Consultation Response from: KC Environmental Health (Pollution & Noise Control)		
2021/91946 - Brenntag UK Ltd, Union Mills, Oxford Road, Gomersal, Cleckheaton, BD19 4JW		
Discharge of conditions 4, 5, 6, 7 & 8 on previous permission no. 2019/93797 for erection of extension to existing warehouse and formation of new car park		
Date Responded: 21st April 2022	Responding Officer: Natalie Heaney	Responding Ref: WK/202119615
Conditions 4, 5, 6 are outside the remit of Environmental Health. In our previous response dated 16th August 2021, we recommended that Condition 7 (unexpected contamination) and Condition 8 (electric vehicle charging points remain). We have since been reconsulted on new information concerning Condition 8 (electric vehicle charging points). Condition 8 – Electric Vehicle Charging Points In our previous response we commented on the following documents: • A supporting statement titled ‘<i>FAO Kirklees Council,</i>’ by HB Projects Ltd dated 10th May 2021 (no reference). • A plan titled ‘<i>Car Park Area Plan – Proposed</i>’ by dated 10th May 2021 HB Projects Ltd dated 10th May 2021 (drawing no. Plan P21-3278-00-01J). Overall, we considered the information insufficient

P21-3278-00-01

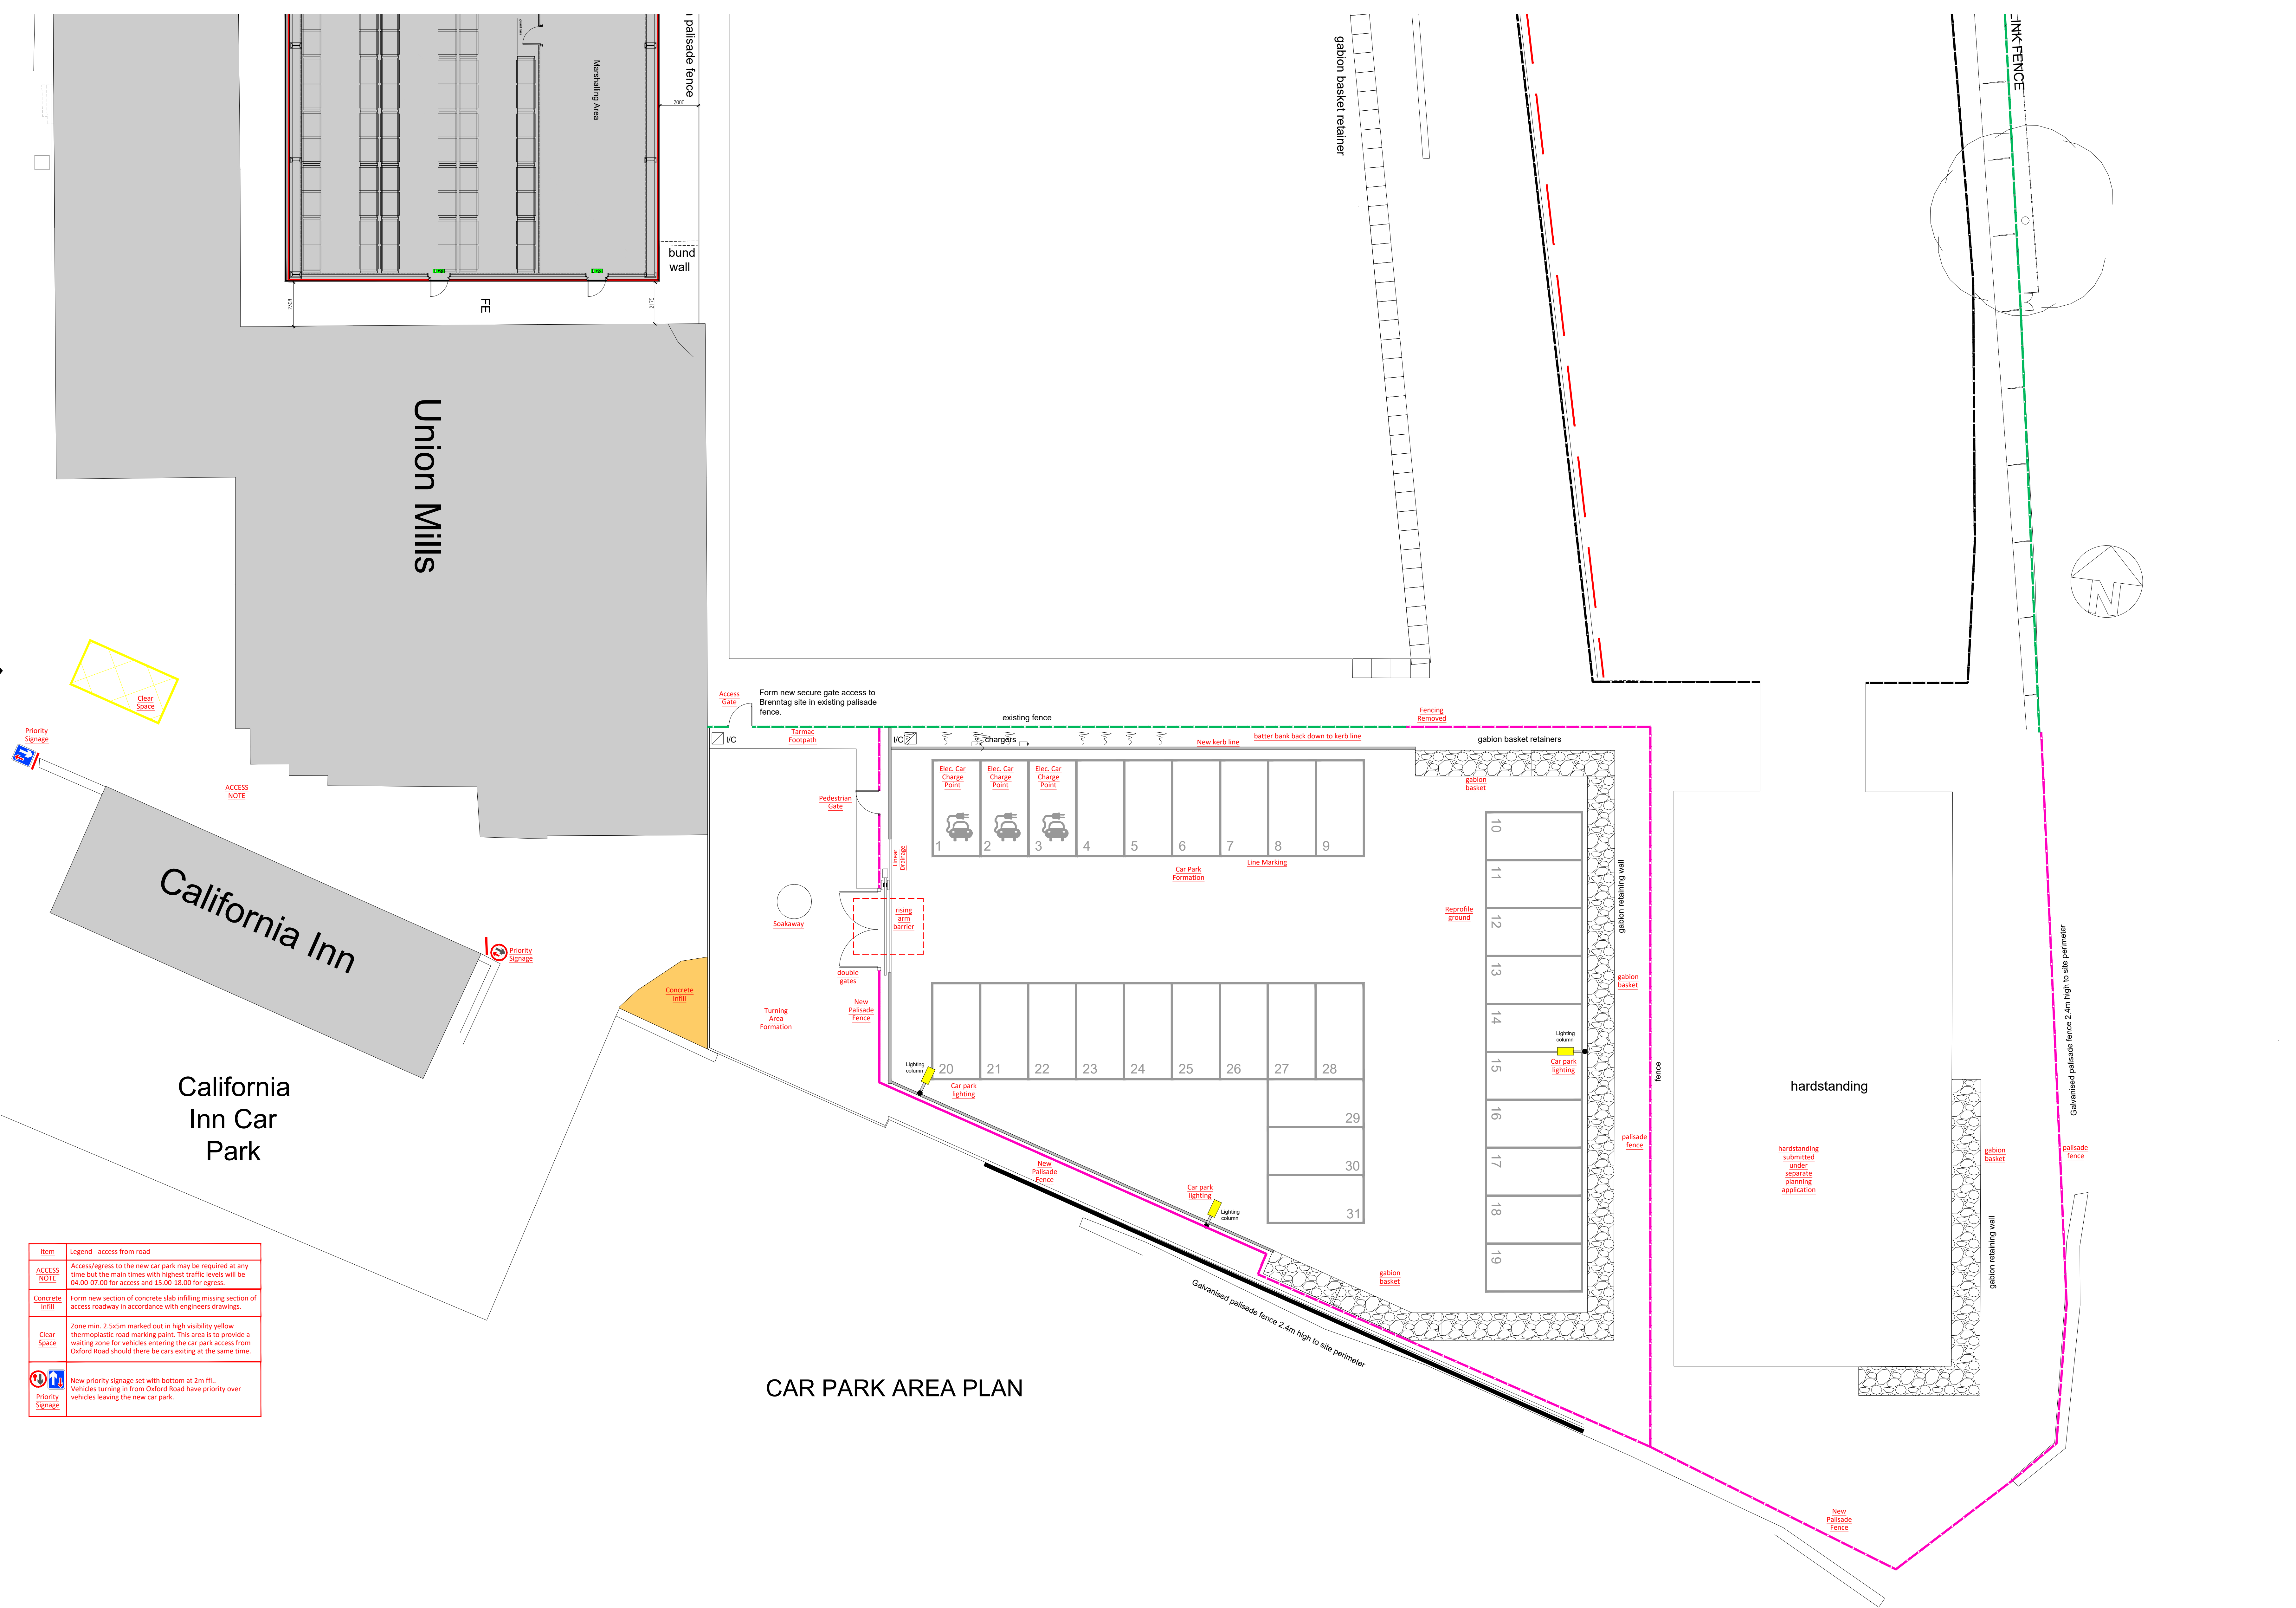
We accept the plan titled '*Car Park Area Plan – Proposed*' by dated 10th May 2021 HB Projects Ltd dated 21st May 2021 (drawing no. Plan P21-3278-00-01K). However, we cannot recommend the discharge of Condition 8 until the electric vehicle charging points are installed in accordance with the plan titled '*Car Park Area Plan – Proposed*' by dated 10th May 2021 HB Projects Ltd dated 21st May 2021 (drawing no. Plan P21-3278-00-01K), and are operational.
